GROSVENOR PLACE NORTH PLAZA

ACCESS REVIEW

10 July 2015

REPORT REVISIONS		
Date	Version	Drawing No / Revision
10.07.2015	Final	DA-4_100_Location Plan, DA-4_101 Site Link George St Level Plan-01, DA-4_102 Site Link Harrington St Level Plan-01, DA-4_103_George Street Level Plan, DA-4_104_Harrington Street Level Plan, DA-4_105_North Plaza Plan, DA-4_106_North Upper Plaza Plan, DA-4_107_Harrington Street Glass Awning and DA-4_108_Elevations & Wayfinding Totem.

DA-4	Drawing Number 104	Issue E
------	-----------------------	------------

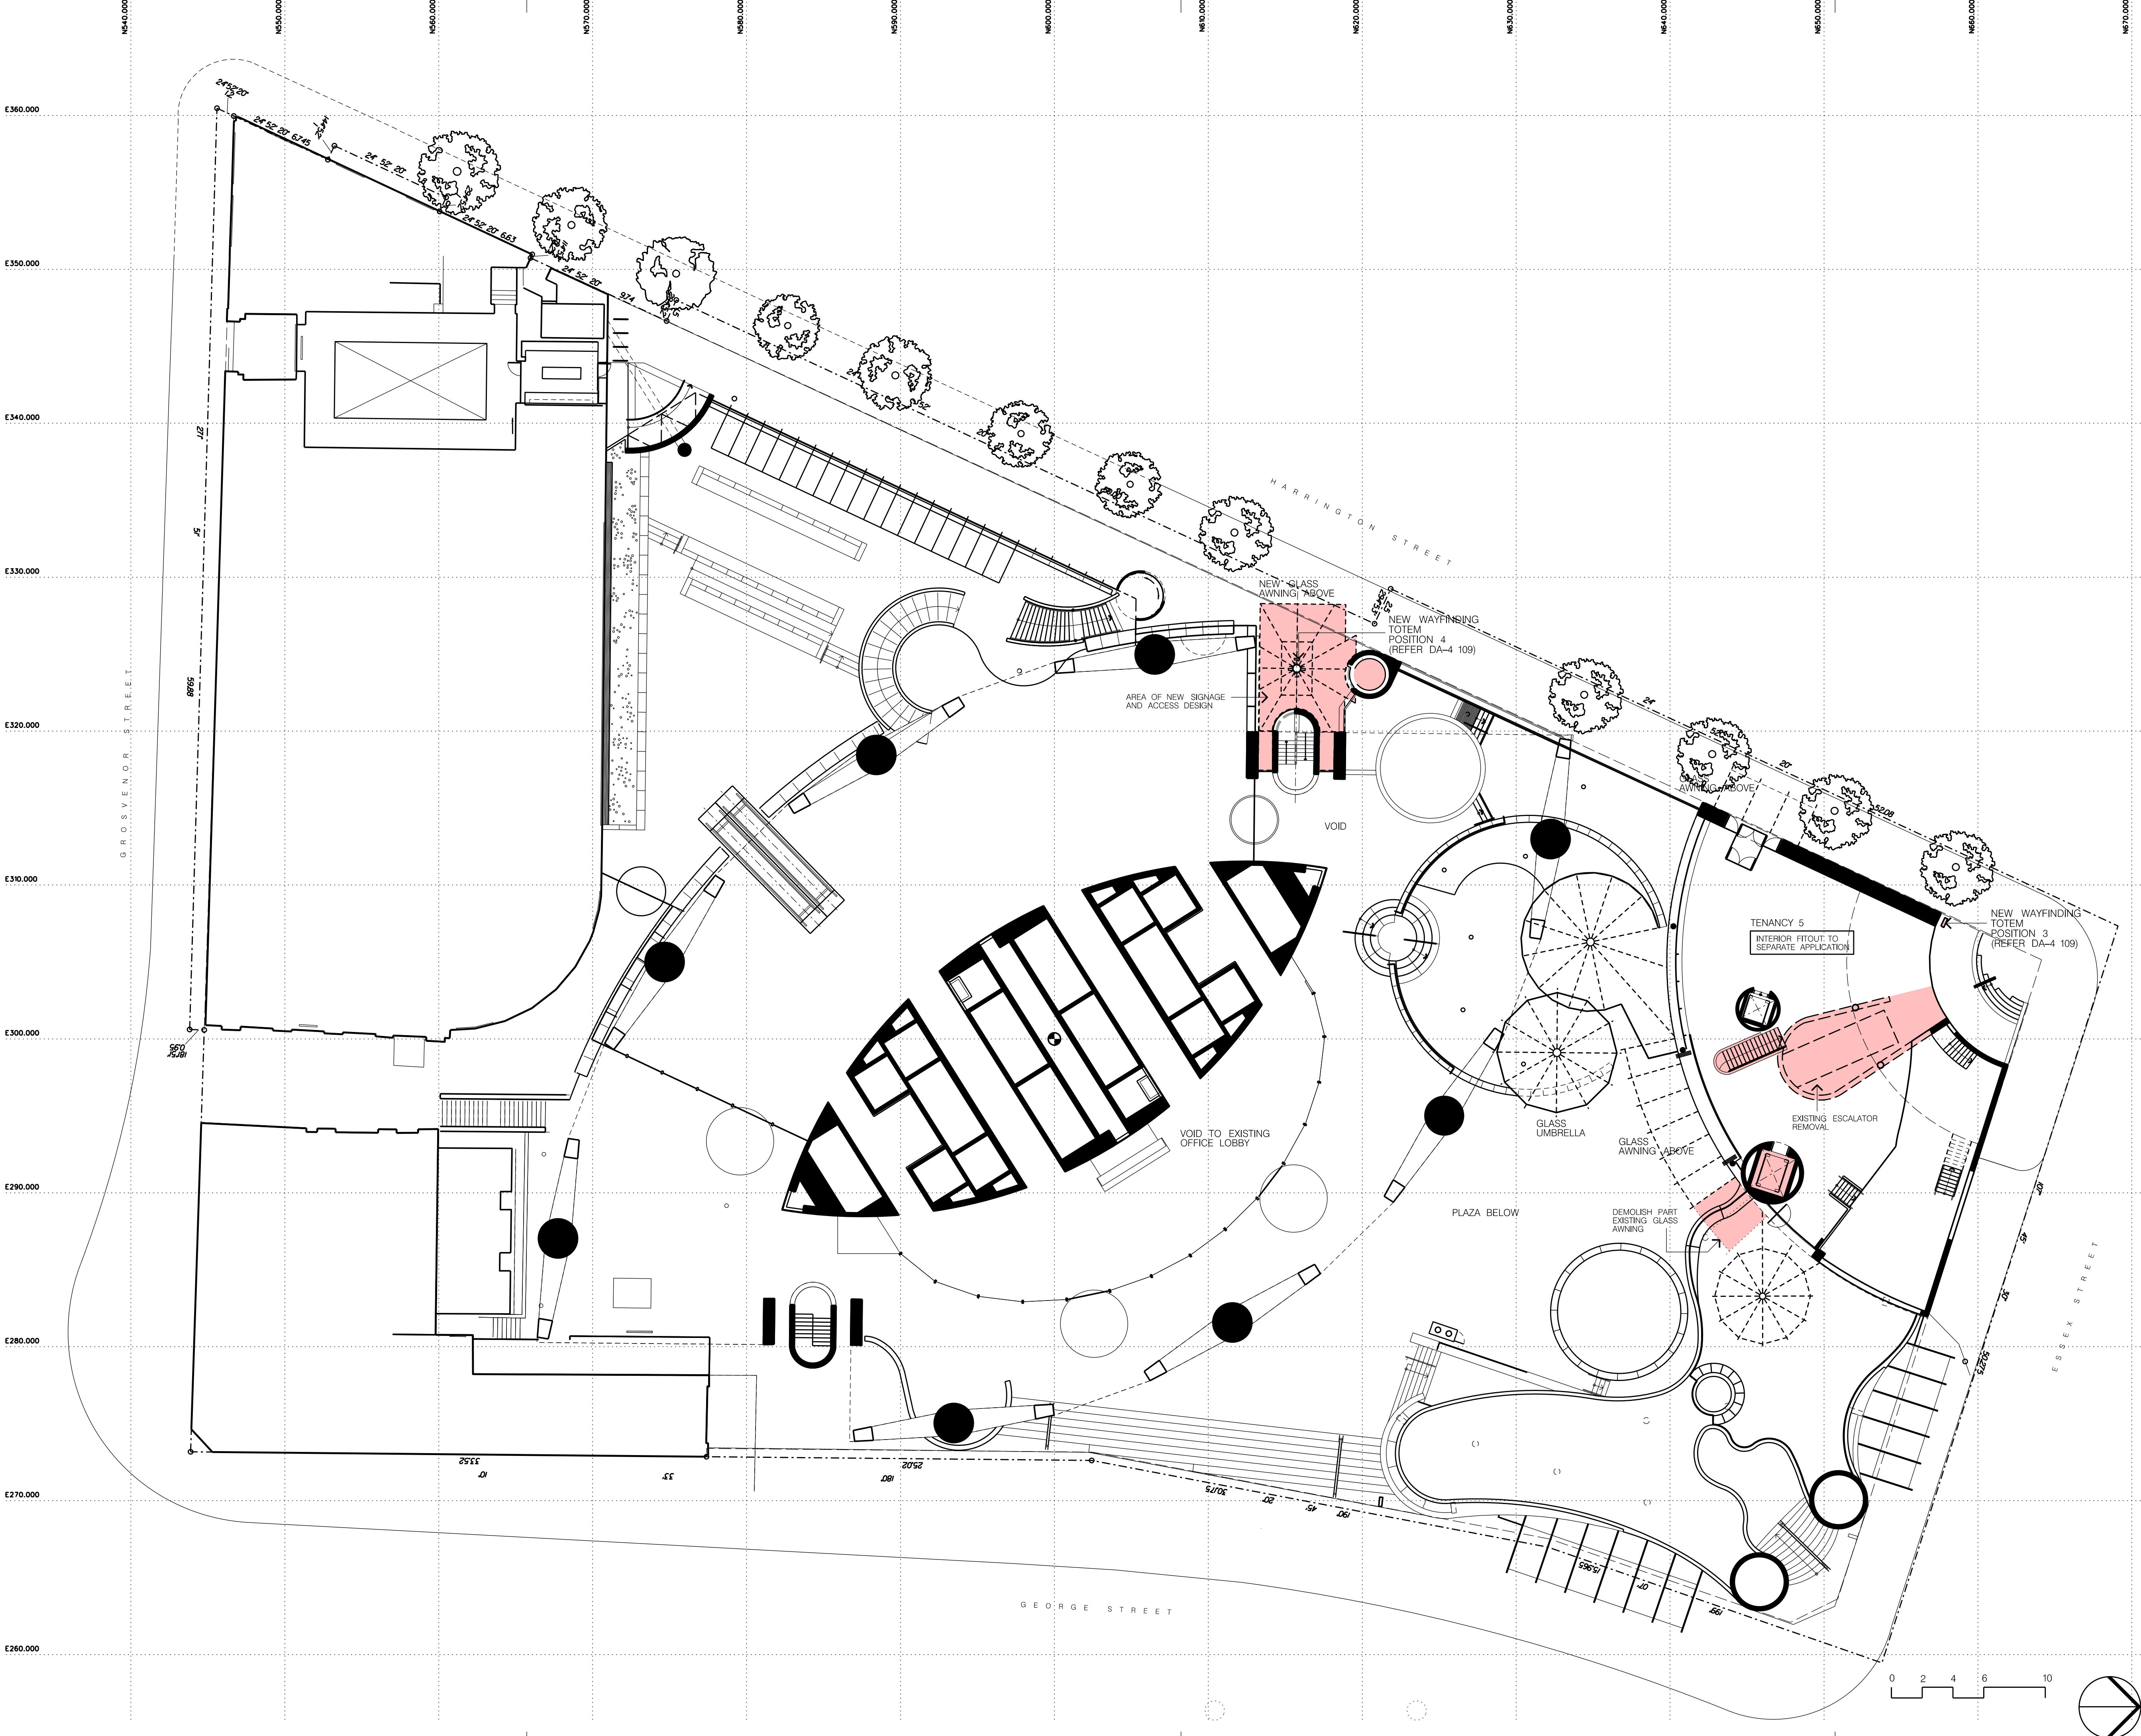
From the information provided the existing escalator within tenancy 5 is to be removed and a new level infill slab installed. Also within this tenancy there is a new stair being installed to provide access to the lobby below. There is an adjacent passenger lift that is accessible from the plaza level and provides wheelchair access to the ground floor of tenancy 5.

- (ii) The Grosvenor Place Plaza has a glazed door that leads to the circular lift, which will need to have suitable warning horizontal band in accordance with AS1428.1-2009.

There is an existing located adjacent the Harrington Street circular passenger lift (ie for wheelchair users). This stair will need to be upgraded to provide pedestrian access from Harrington St to the Grosvenor Place Plaza below as per the requirements of AS1428.1-2009.

From the information provided within tenancy 5 there is a new stair being installed to provide access to the lobby.

- (i) Provide handrails and TGSi at the stair within tenancy 5 as well as the existing stair adjacent the passenger lift in accordance with AS1428.1-2009.
